From: [Chad Bala](#)
To: [Josh Fredrickson](#)
Cc: [Kelly Bacon \(CD\)](#)
Subject: BL-22-00009 Revisions
Date: Thursday, November 10, 2022 2:55:14 PM
Attachments: [22140 BLA_Rev11_10.pdf](#)
[BL-22-00009 Palomino Fields Div 8 Lot 6 KCPW Plan Review Team 2nd survey review 11-2-22.pdf](#)

I have had WPE make the revisions regarding the DPW comment letter dated 11-2-22 (see letter attached).

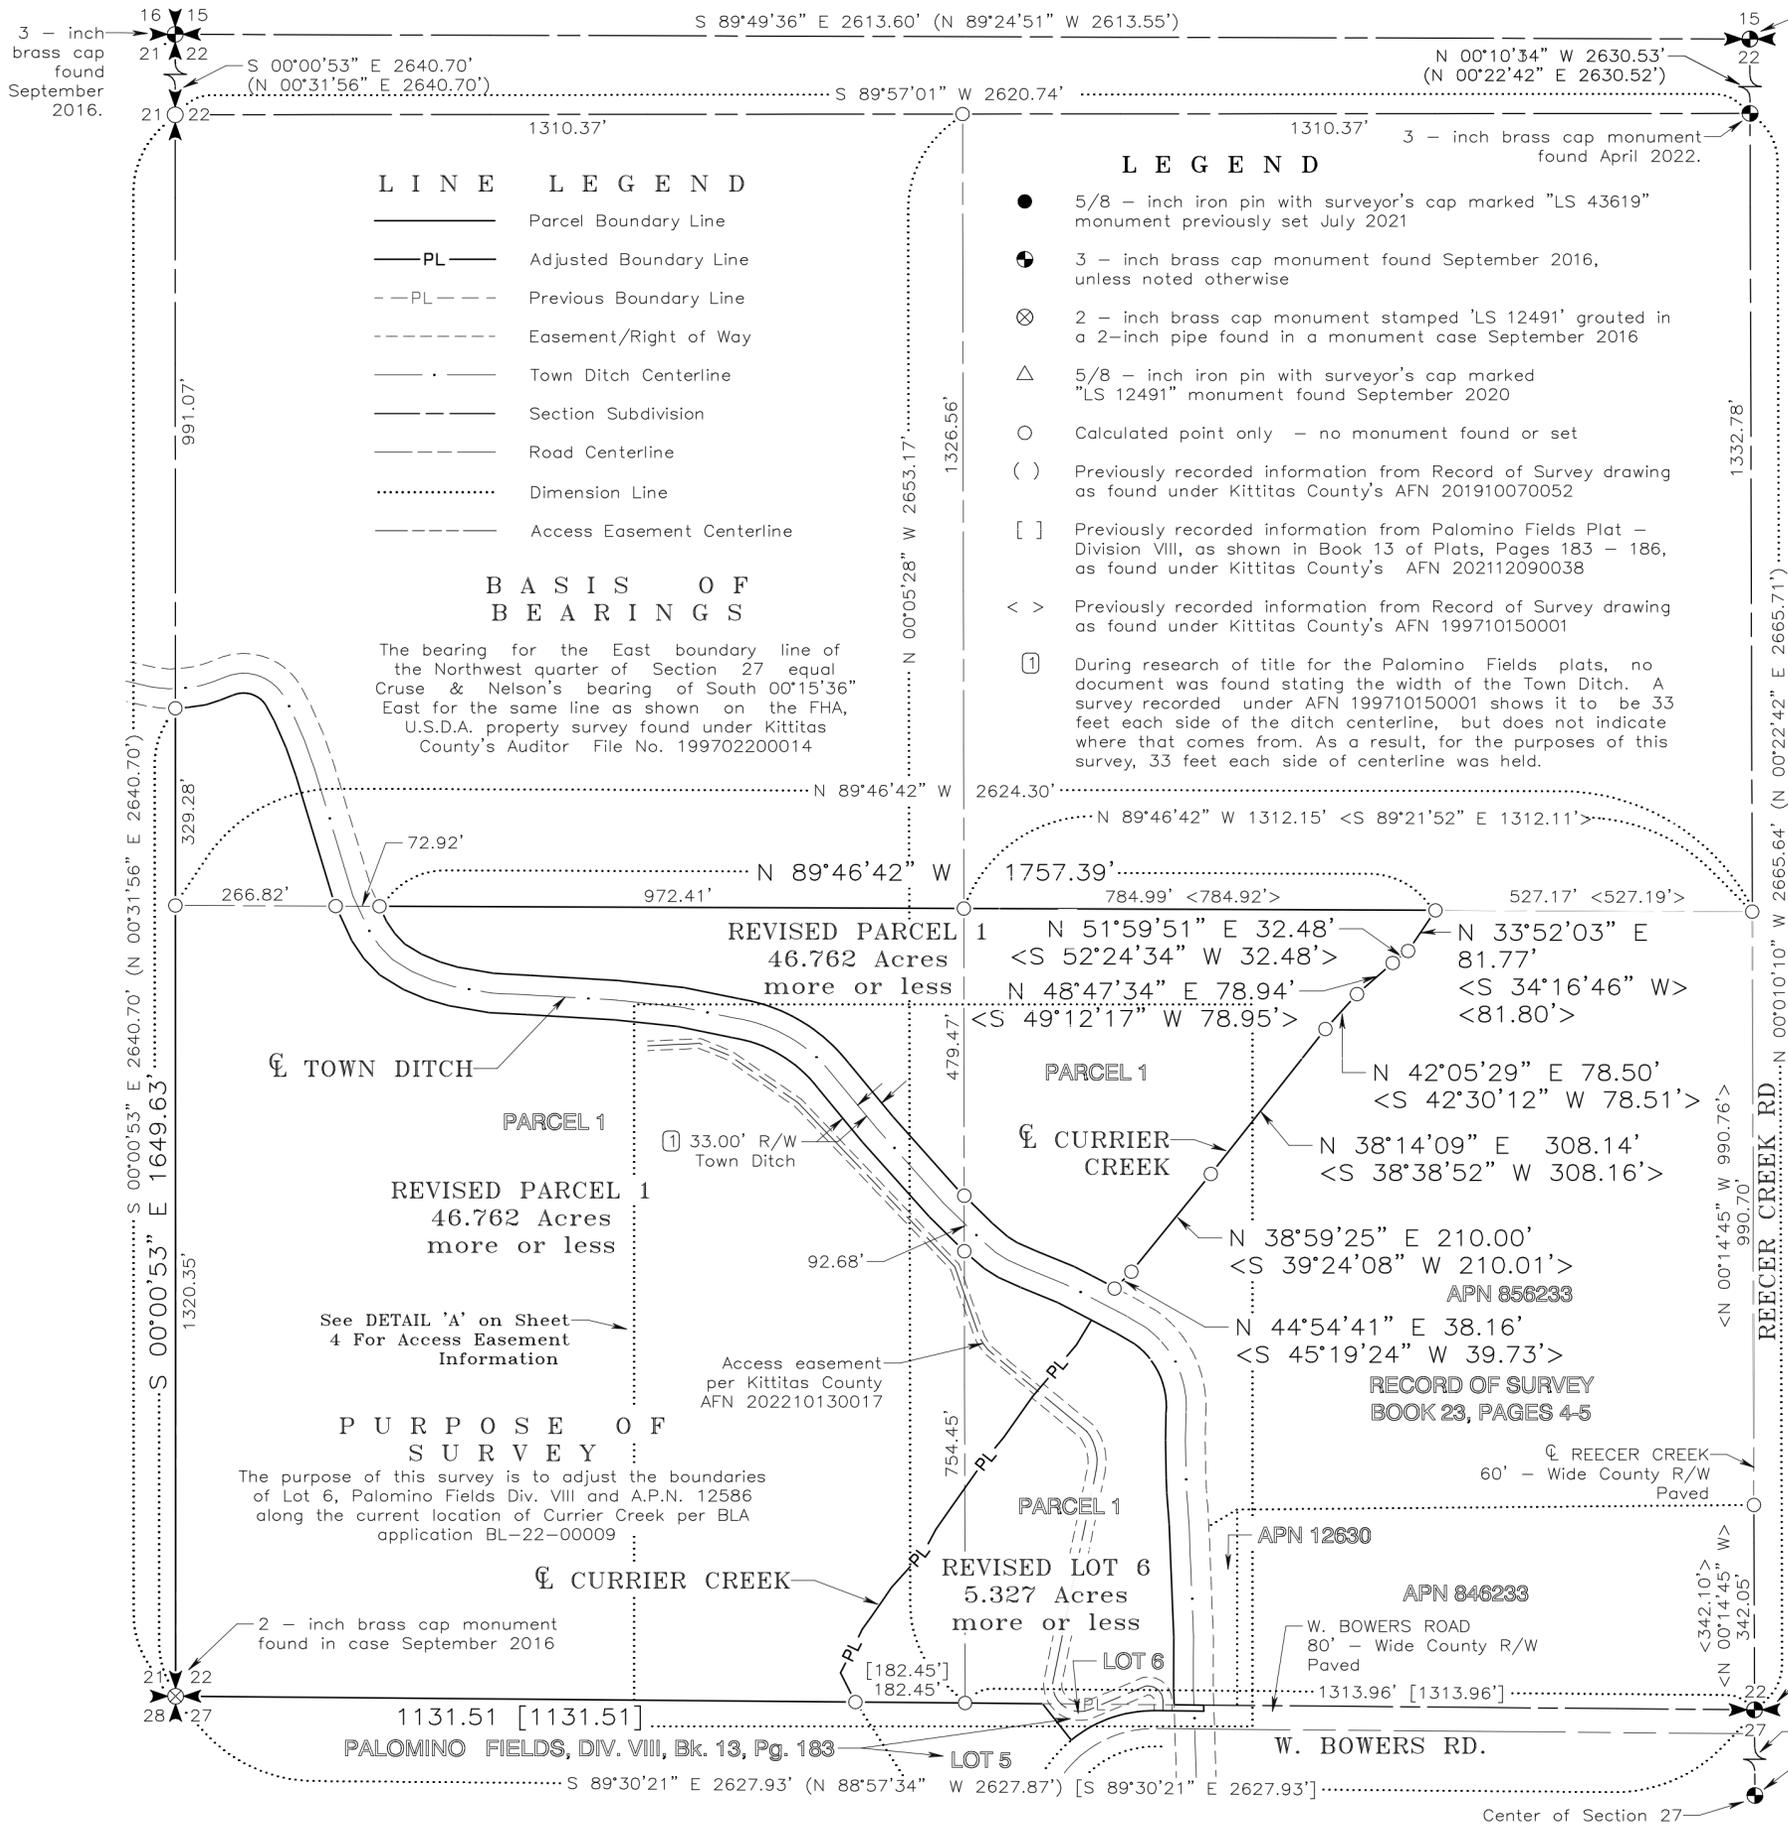
See Sheet 1 satisfying DPW survey comment #3 regarding Book and Page of property to the east.

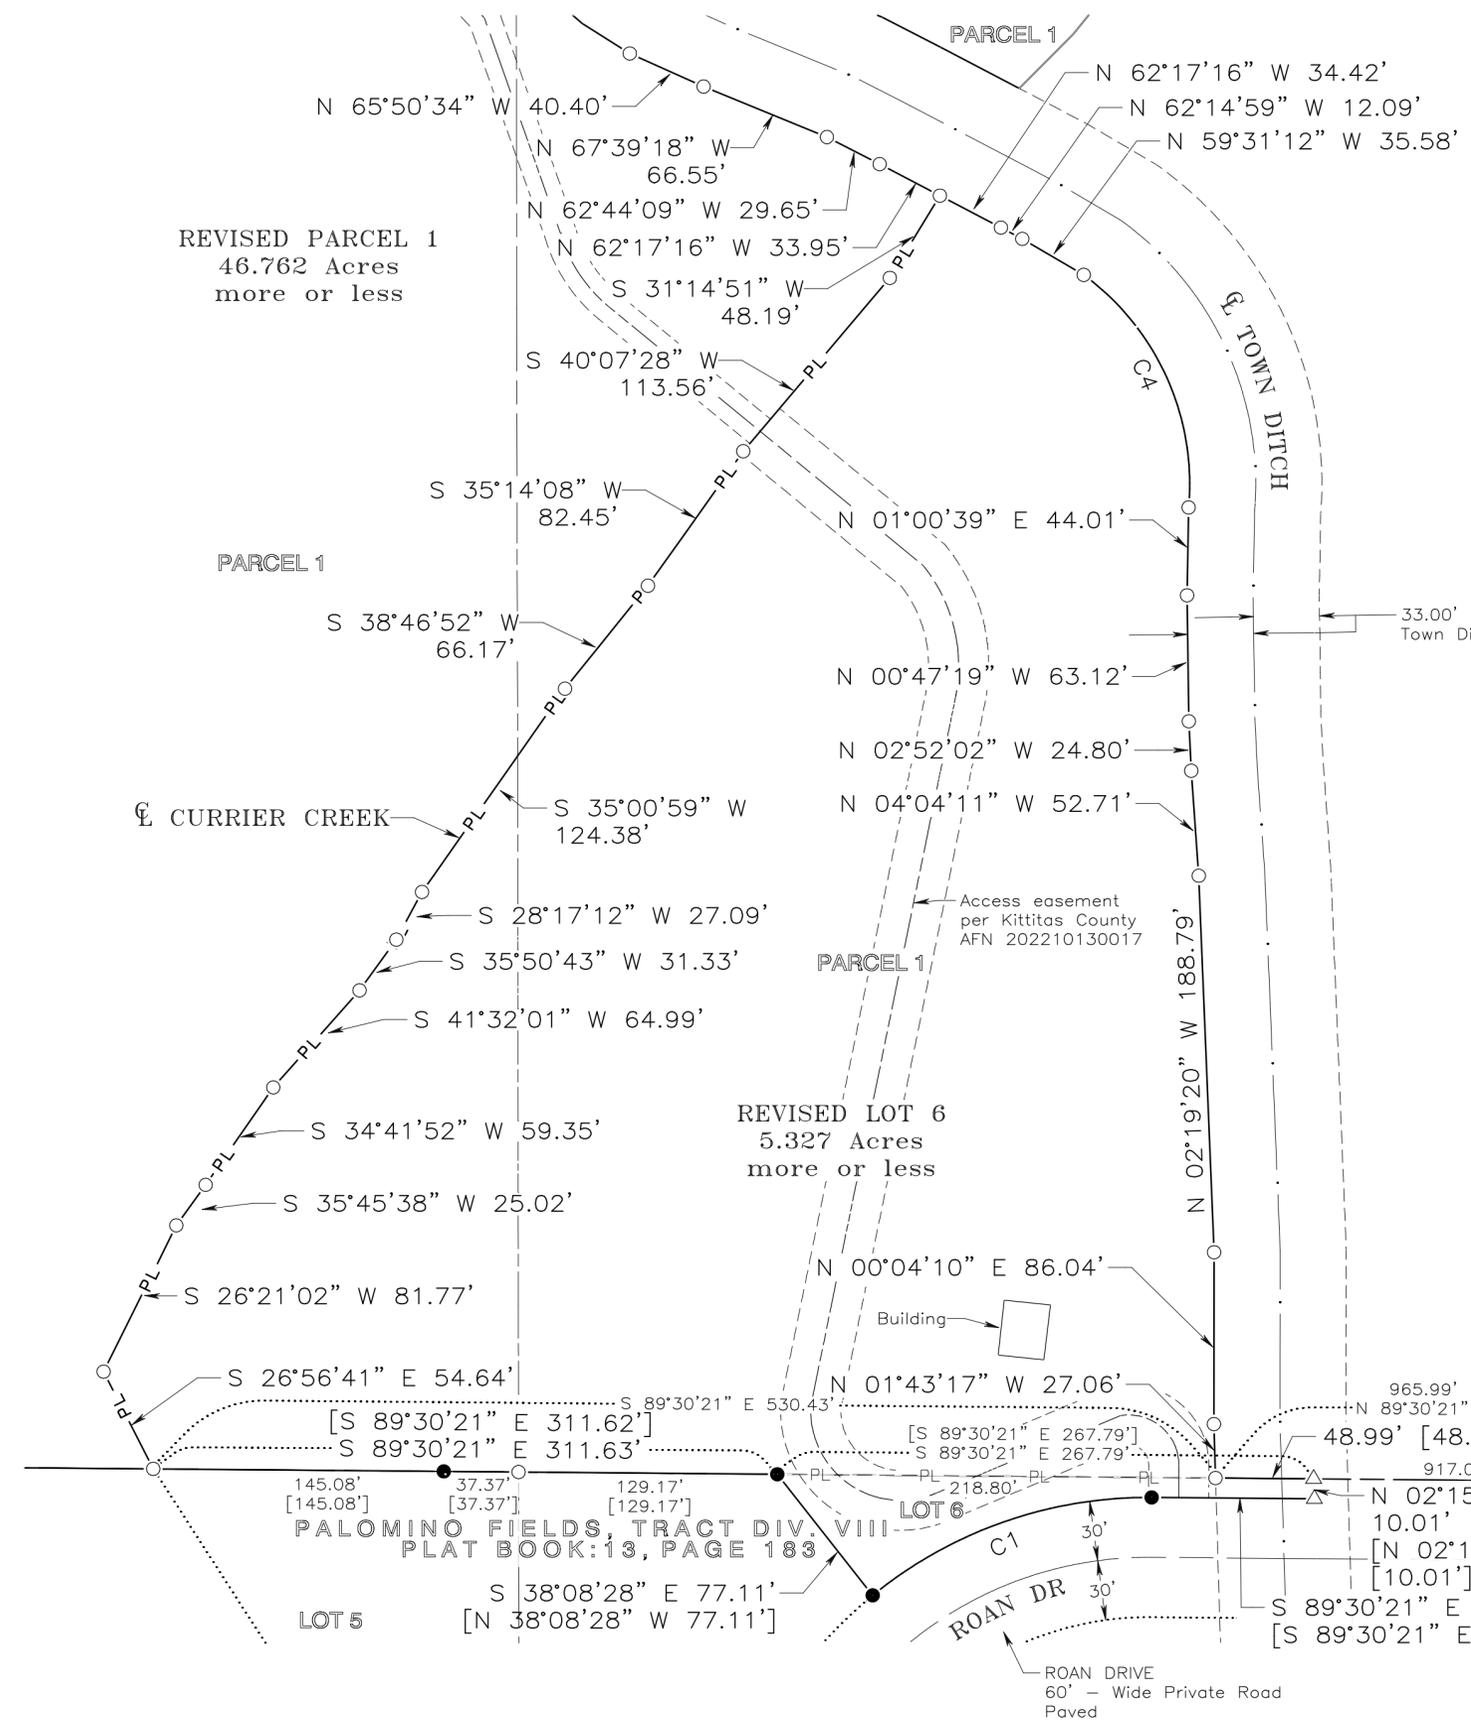
See Sheet 1 and 2 satisfying DPW survey comment #4 regarding right of way widths for Roan Dr., W. Bowers Rd., and Reecer Creek Road.
